Re:Planning Application No: 3/2023/0257

I object to this latest proposal for the construction of 3 holiday cottages which if successful would supersede the plans submitted in application 3/2020/0498.

EXISTING SITE PLAN
SCALE 1:200
0 5 10 15m

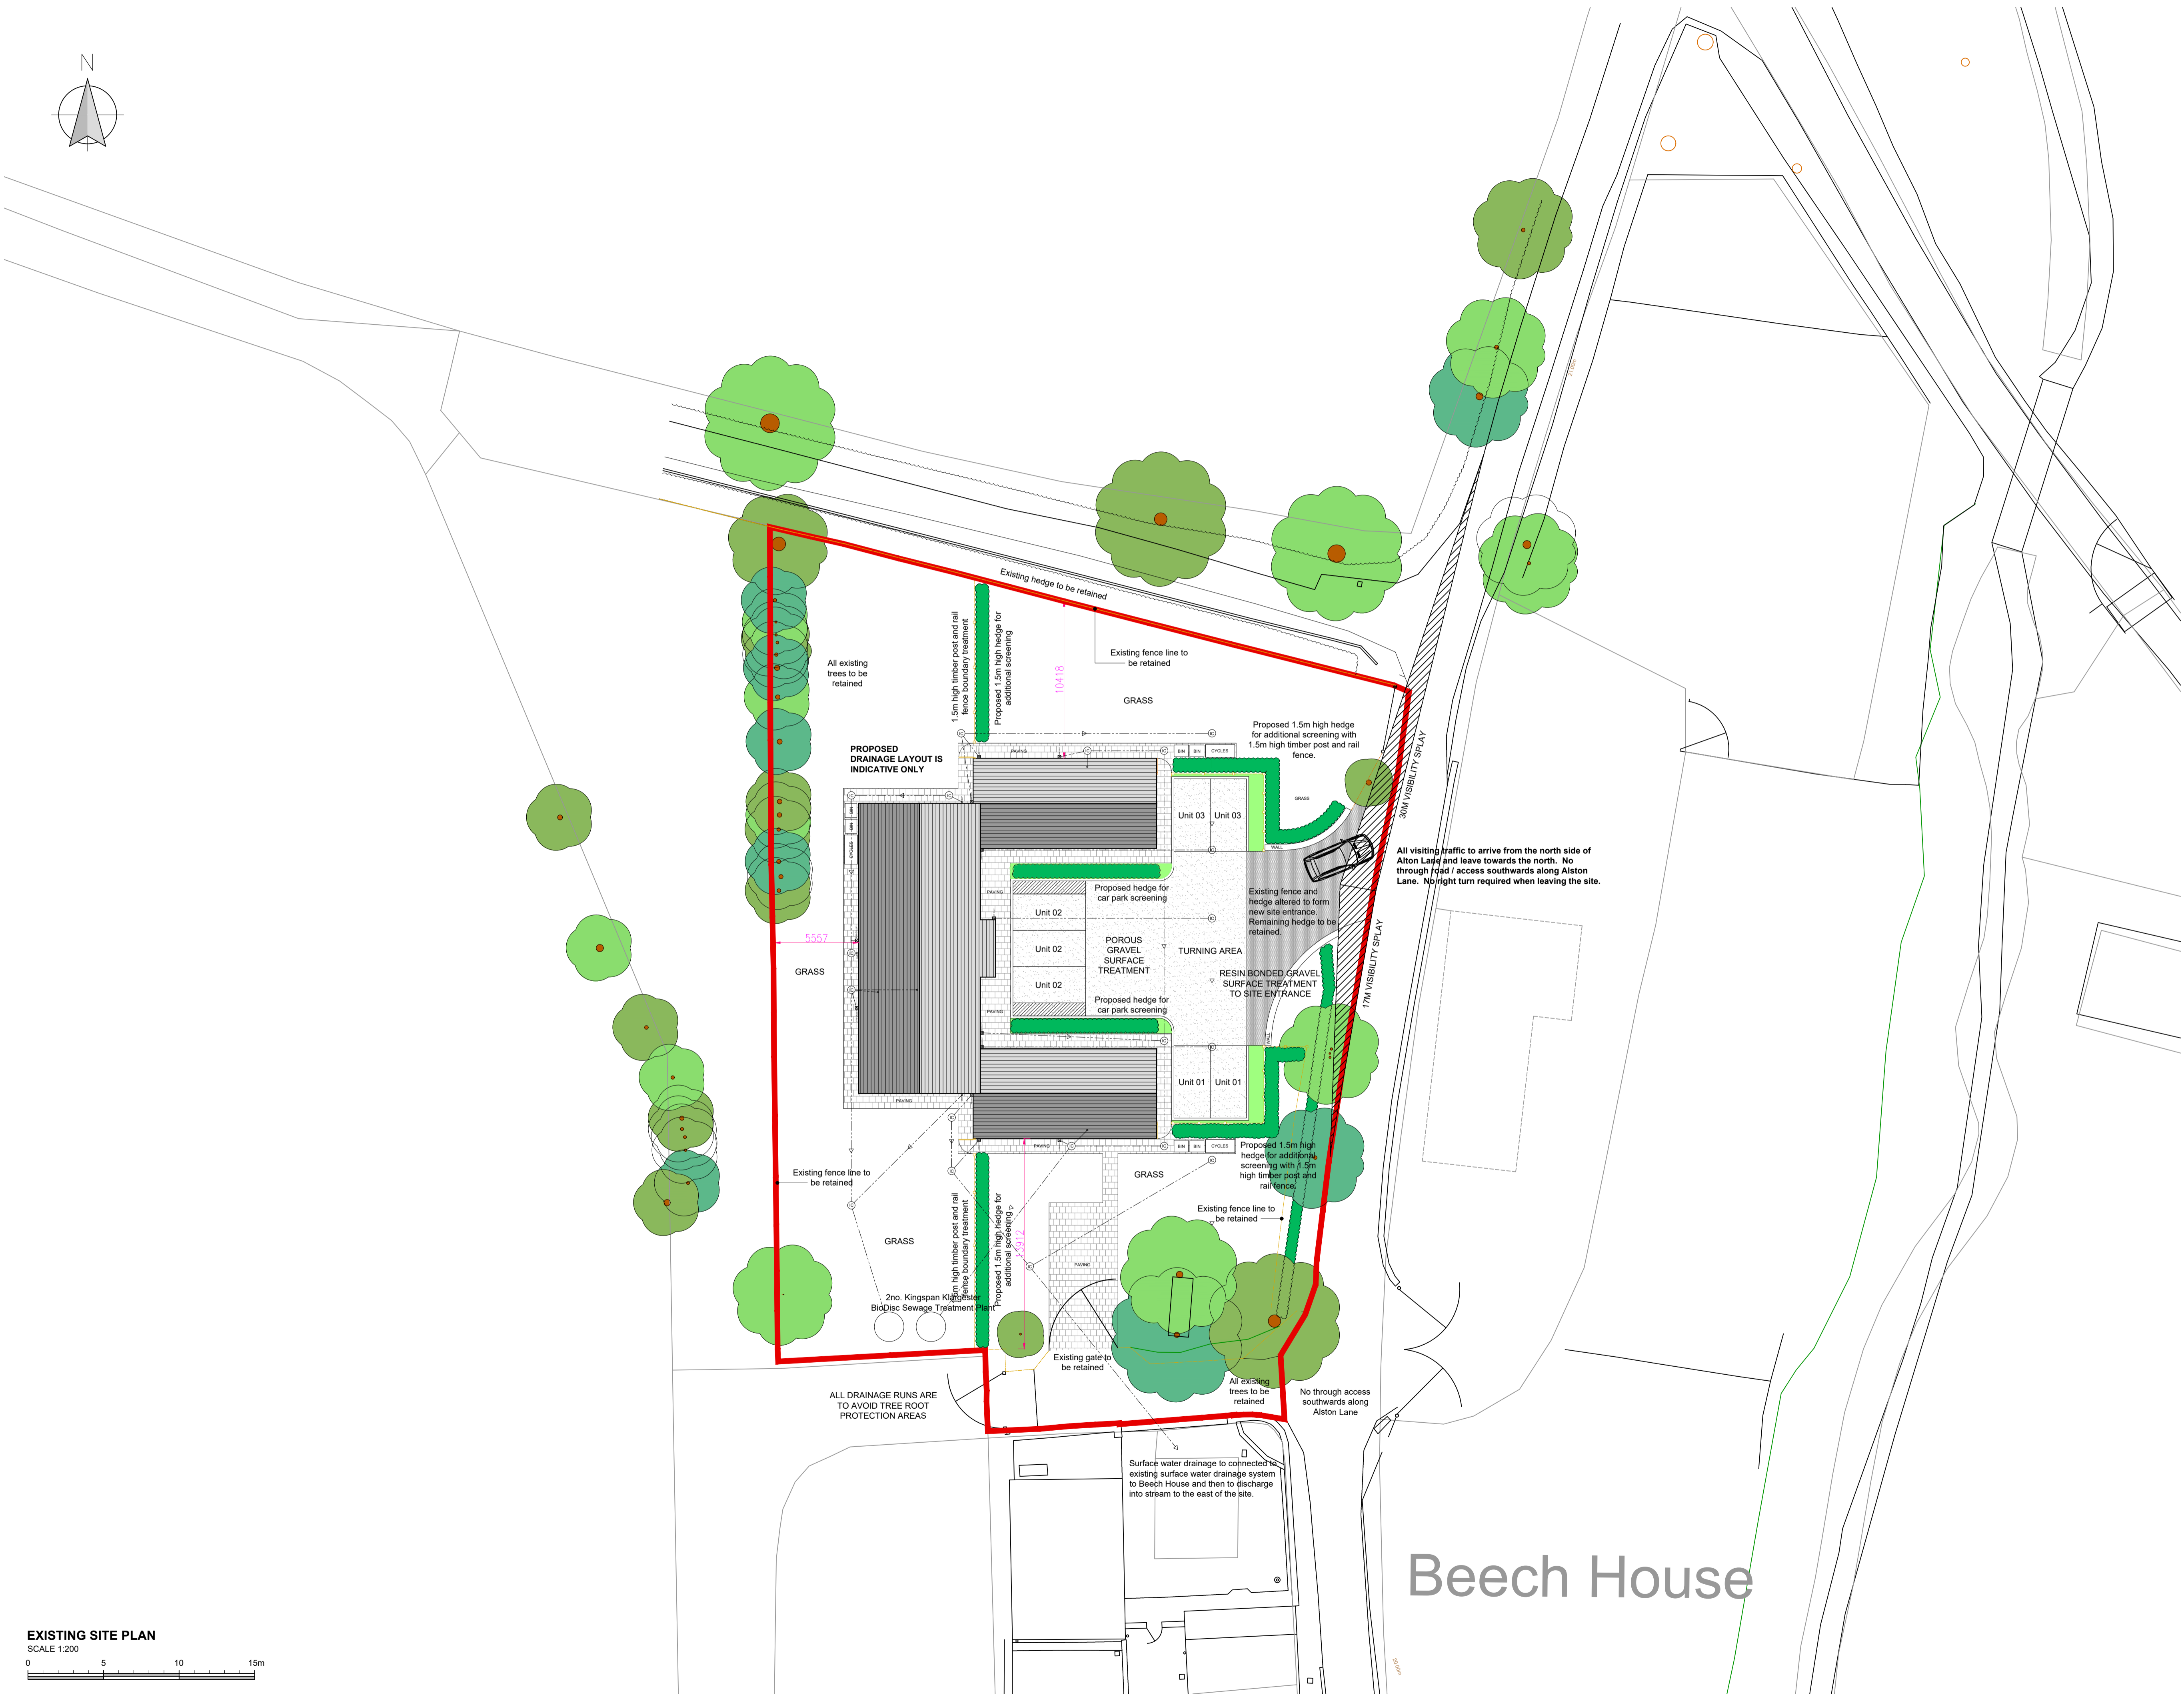
Secondly, although on the plan the difference in height does not seem significant, in reality, as the attached photographs show, the difference is significant. The pitch of the roof and height of adjoining wall are much taller than one would expect from the plans.

You will note from two of the photographs that provision for velux windows has been made in the construction of the roof. I suppose [REDACTED] is confident his proposed amendments will be approved but I do object to this alteration from the original application on the grounds of light pollution. Although the original application states: 6.4 'The buildings and gardens are well-screened from the landscape beyond by the existing trees and hedges around the site', you can see from the first photo that this is somewhat of an exaggeration.
